My reference: 3/2021/0585
Direct Dial: (01200) 425111
www.ribblevalley.gov.uk
Email: planning@ribblevalley.gov.uk
Date: 01 July 2021

Location: 39 Clitheroe Road Whalley BB7 9AD

Proposal: Discharge of Conditions 3 (Highway Details) 4 (Tree Works) 5 (Arboricultural Statement) of planning application 3/2017/0849.

4386 - L01	REV -
------------	----------

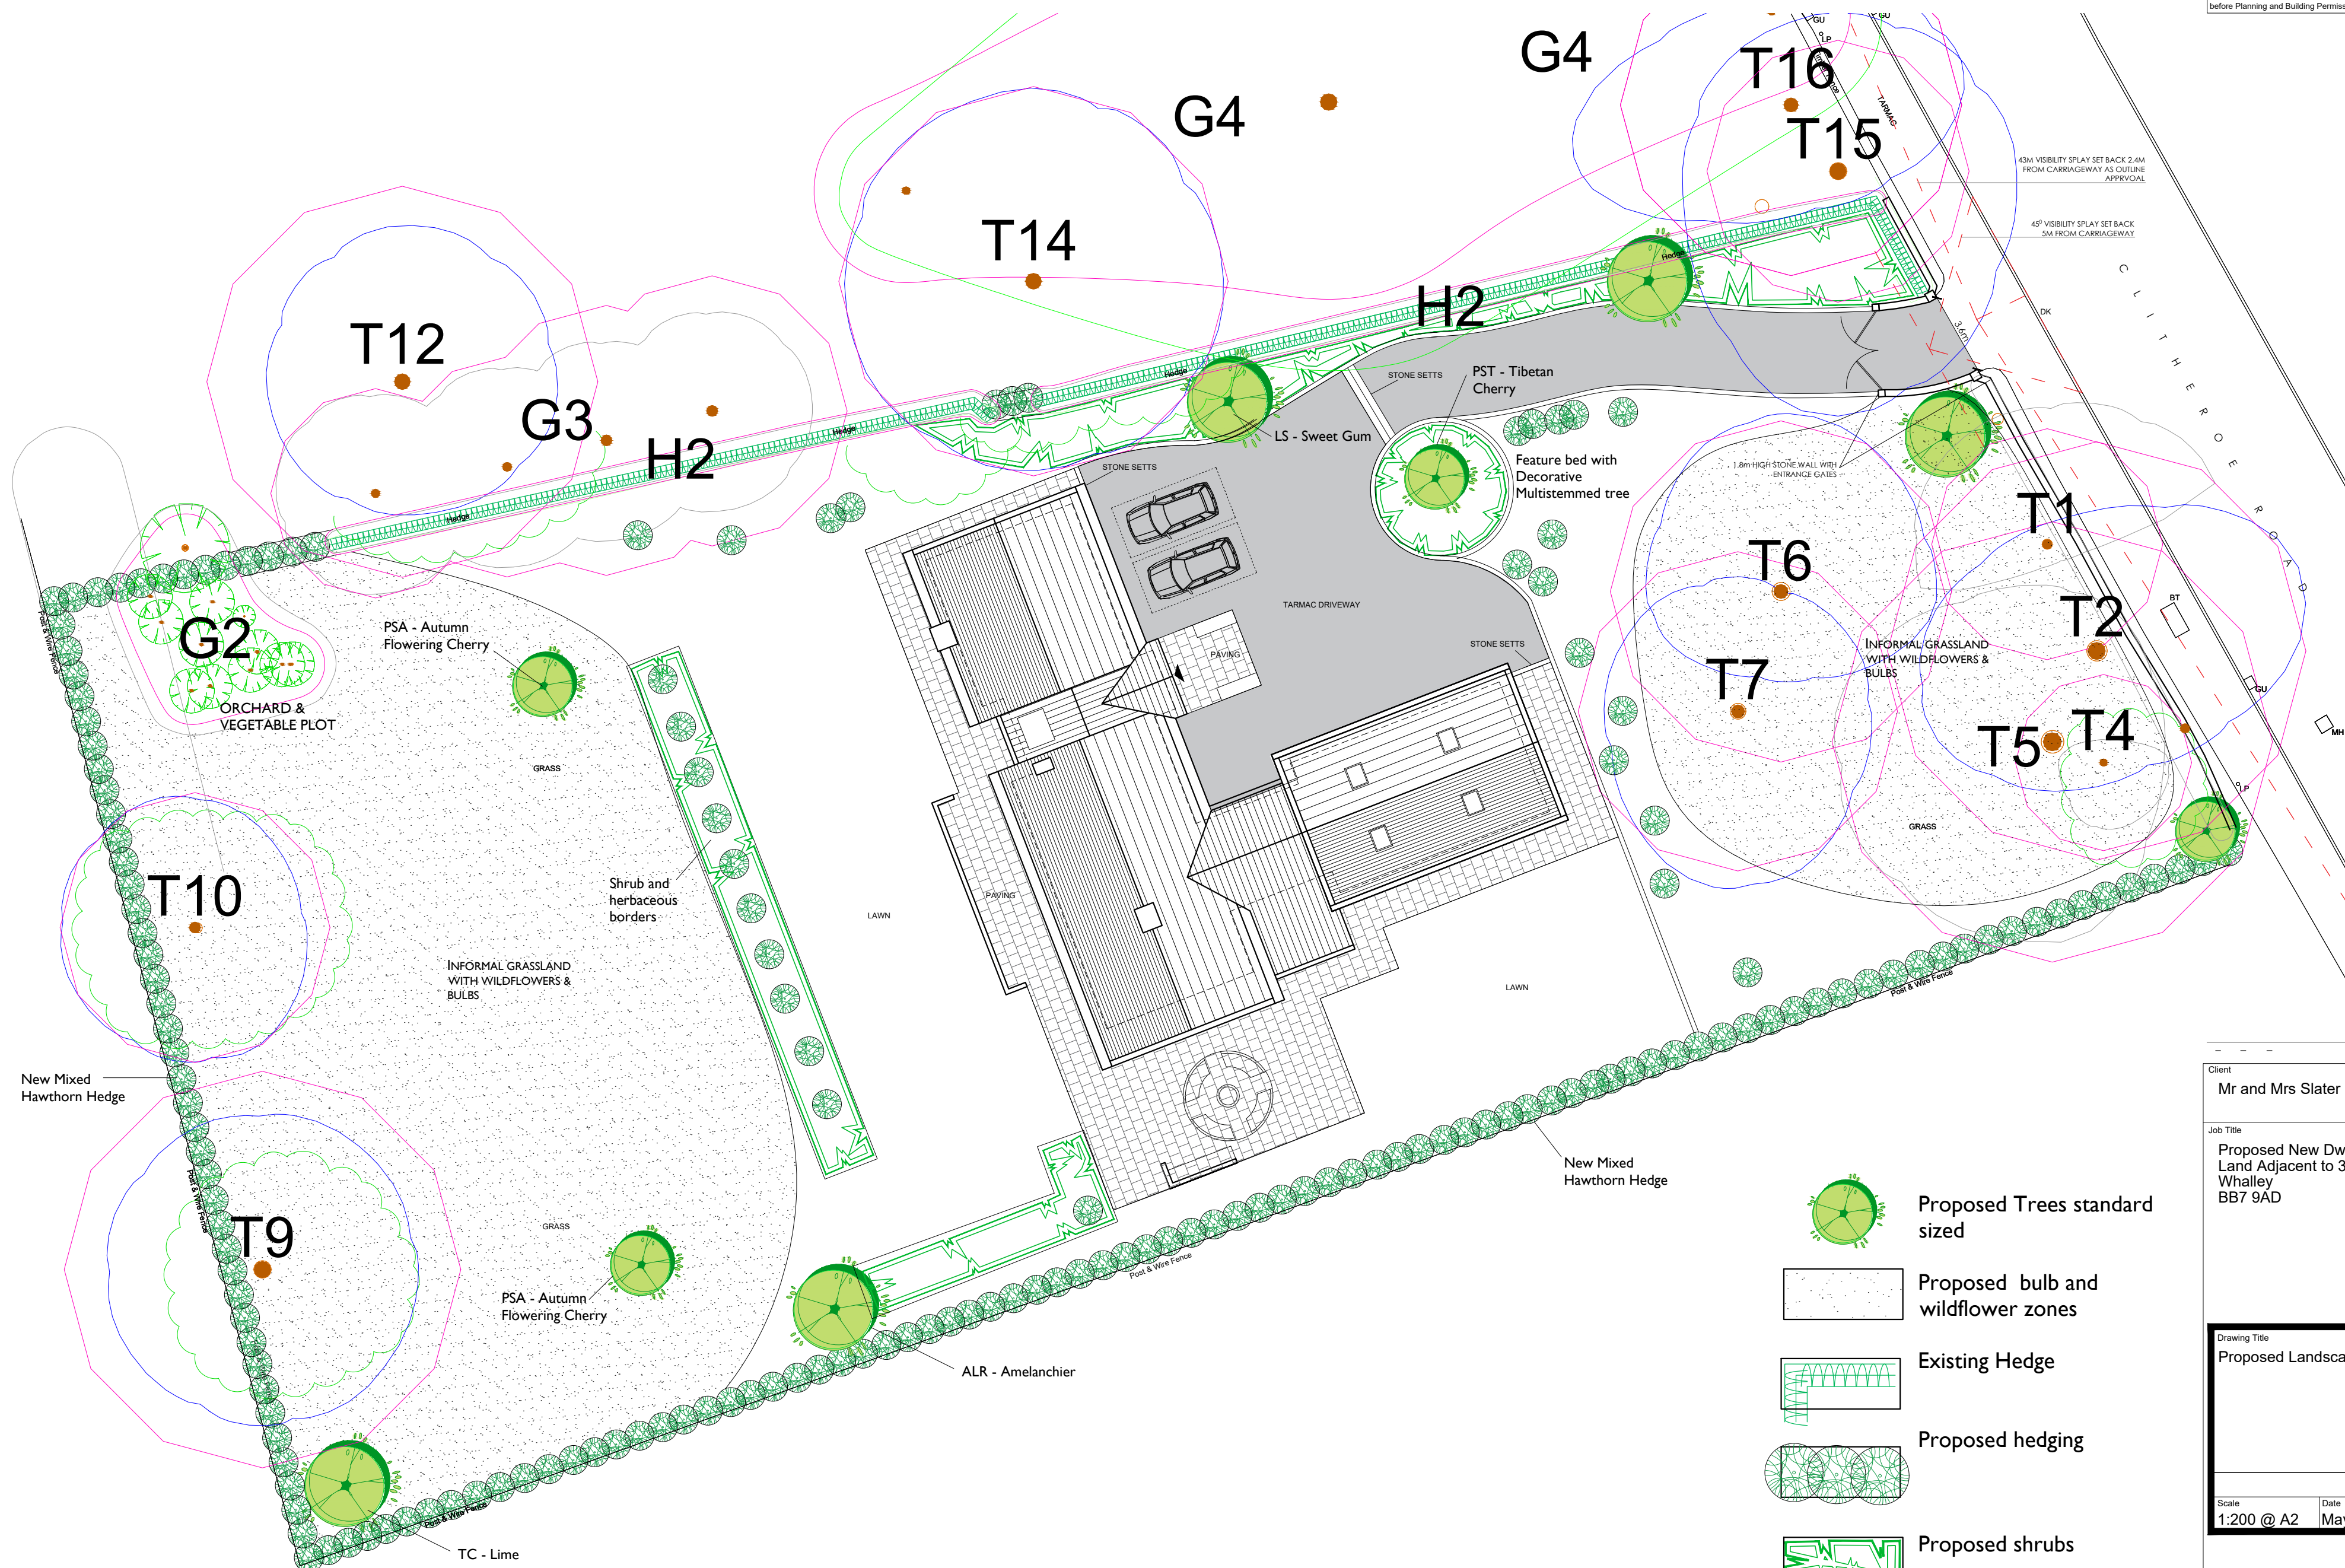
Condition 3 is partially discharged insofar that the proposed details relating to the surfacing of the vehicular access (4386-M01 and 4386-L01) are considered to satisfy the requirements of the condition.

The condition can only be partially discharged at this stage insofar that the condition requires the agreed details be implemented as approved. Upon the development having been completed in strict accordance with the approved details this condition shall be fully discharged.
